WEST SUSSEX COUNTY COUNCIL CONSULTATION

TO:	Arun District Council FAO: Maria Tomalova
FROM:	WSCC - Highways Authority
DATE:	6 April 2021
LOCATION:	Iluka, 22 Broadmark Lane, Rustington, BN16 2HJ
SUBJECT:	R/43/21/HH Single store attached garage to side.
DATE OF SITE VISIT:	N/A
RECOMMENDATION:	Advice
S106 CONTRIBUTION TOTAL:	N/A

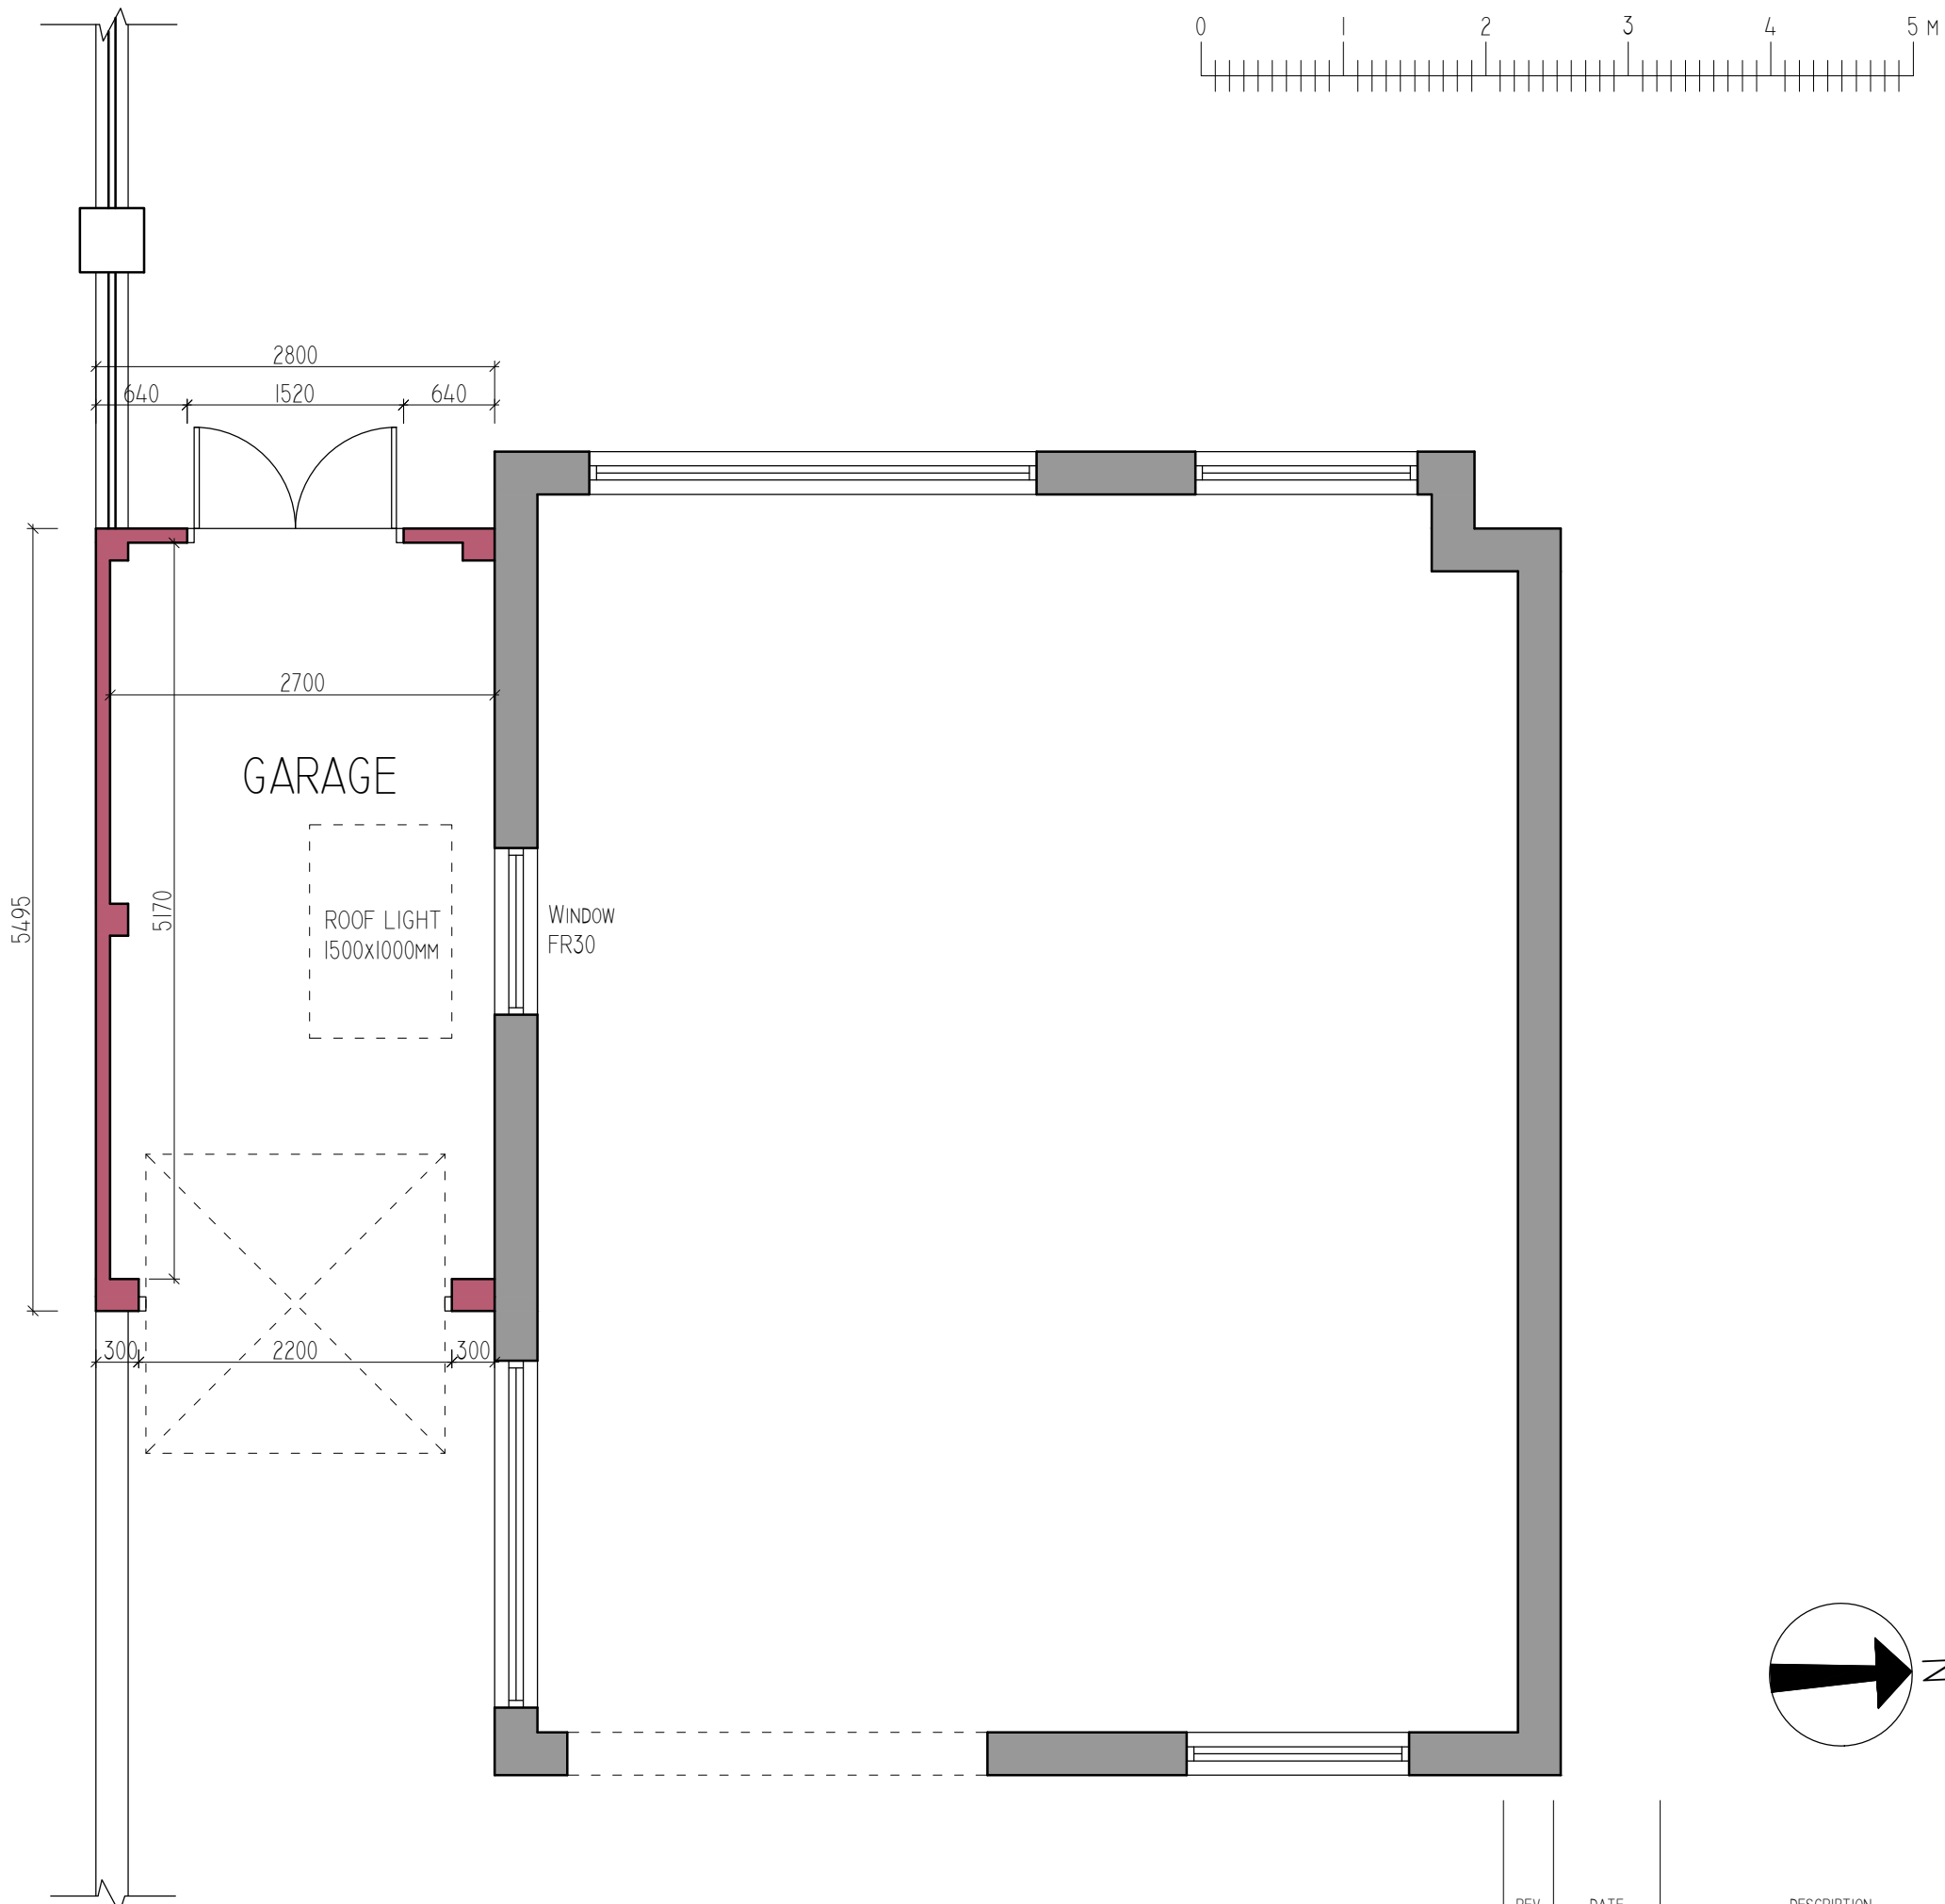
From inspection of the plans, the proposed garage has approximate internal dimensions of 2.7m x 5.2m. This does not meet the minimum specifications for single-car garages of 3m x 6m, as set out in Manual for Streets (MfS). Therefore, the LHA advises the applicant to enlarge the garage to meet MfS specifications, as it may be too small for modern cars to fit inside. However, the LHA acknowledges that the size of the garage is limited by site constraints.
